We are writing to you to express some concerns over the recent application 6/2023/0005/
HOUSE

1-Proposed site plan doc code: P3

Existing Shed
Ground Floor & Roof Plan
Front Elevation & Section

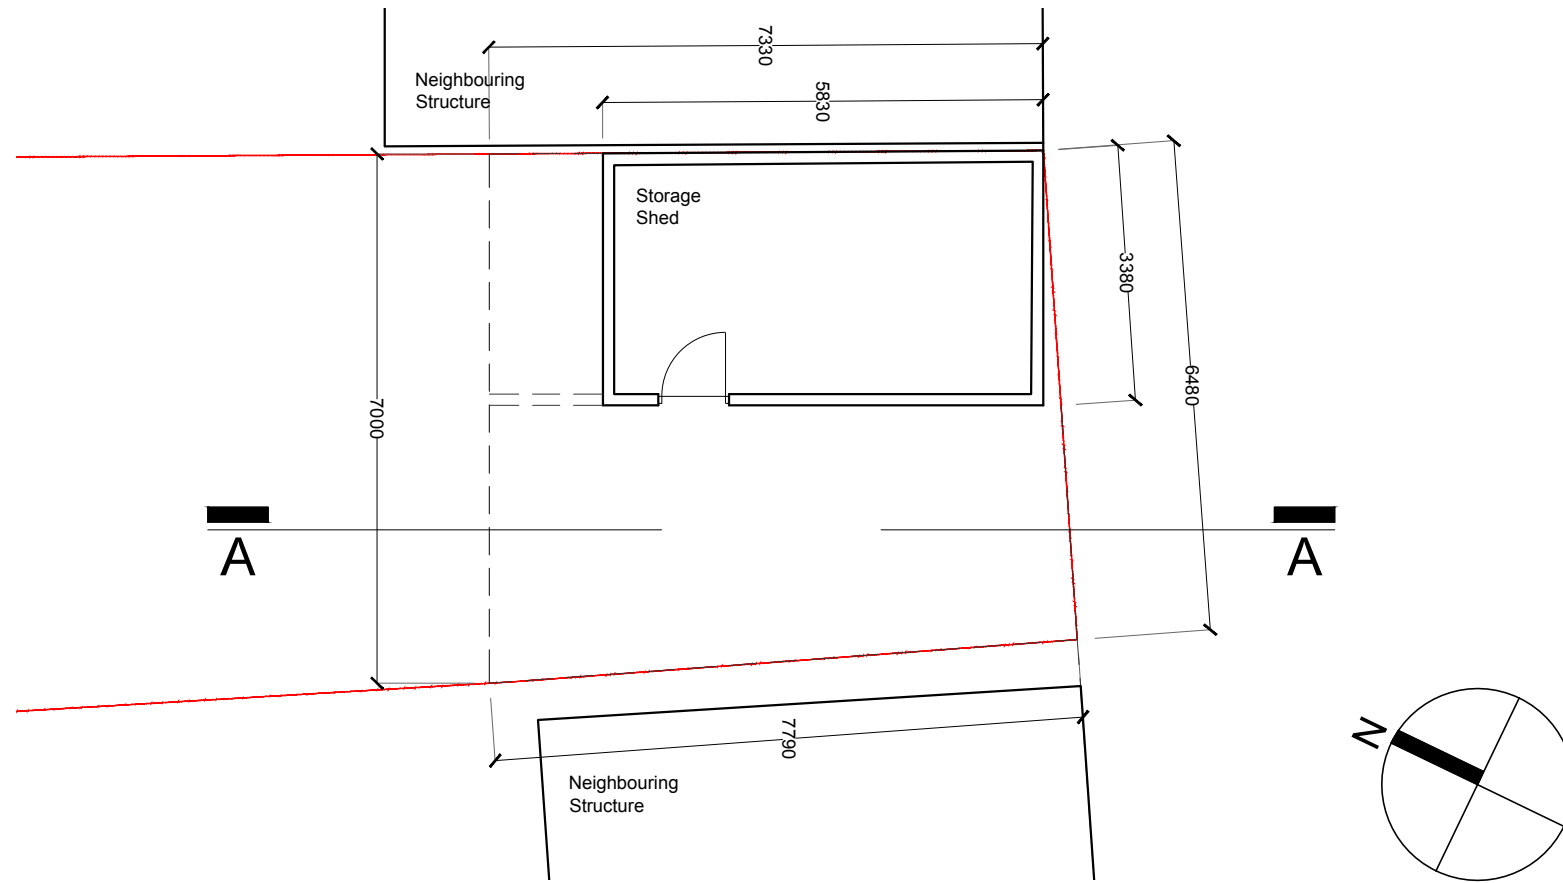
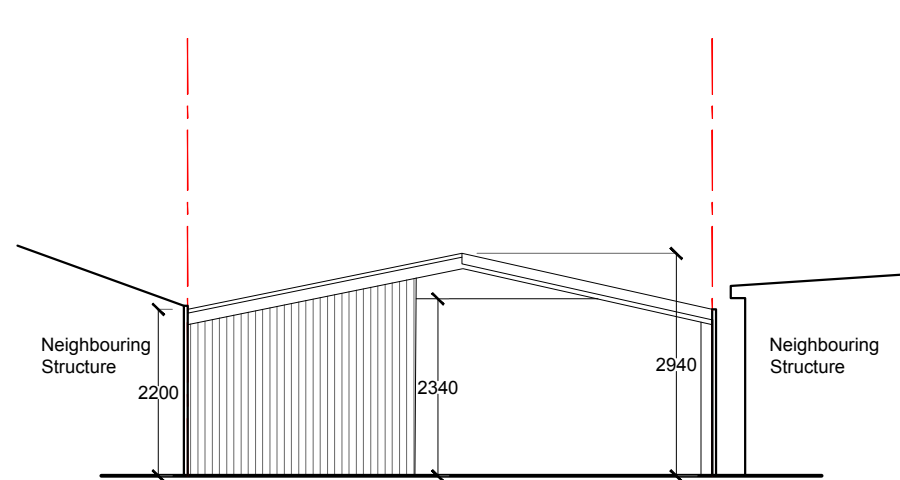
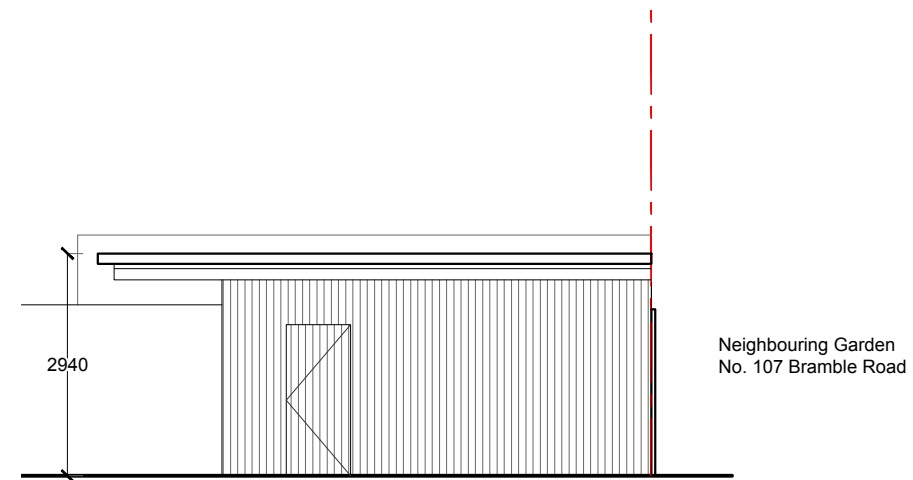
The site plans have omitted the existing outbuilding that is near the main house and we assume its built on the public sewage. Does this mean that the outbuilding near the main dwelling is going to be removed or directly connected with the main house? According to the older documents supplied under this address it states (quoted from the document *2014-2413.pdf*):

Proposed Ground Floor Plan

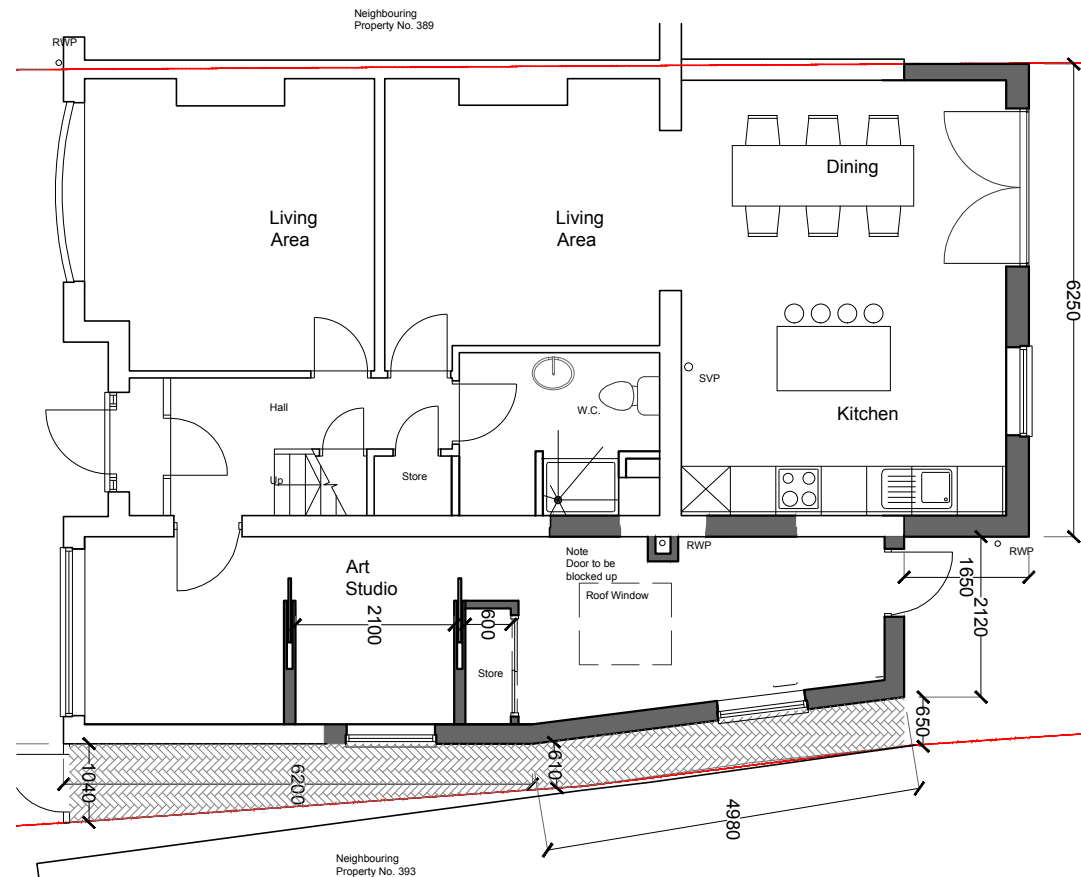
Another concern for this outbuilding that we have is that the plans show one bigger than allowed, in that the building has two entrances and we assume shower bathrooms with a diving wall which does not resembles games room as stated on the document for the same space. This leads us to believe that the space might not be used as stated in the lawful documentation.

Outbuilding is not present near the main house on this existing plans. But looking at the proposed plans it seems that the space is marked and also has shower /toilet as part of it. On this plan it only shows back of the garden outbuilding named “storage shed”.
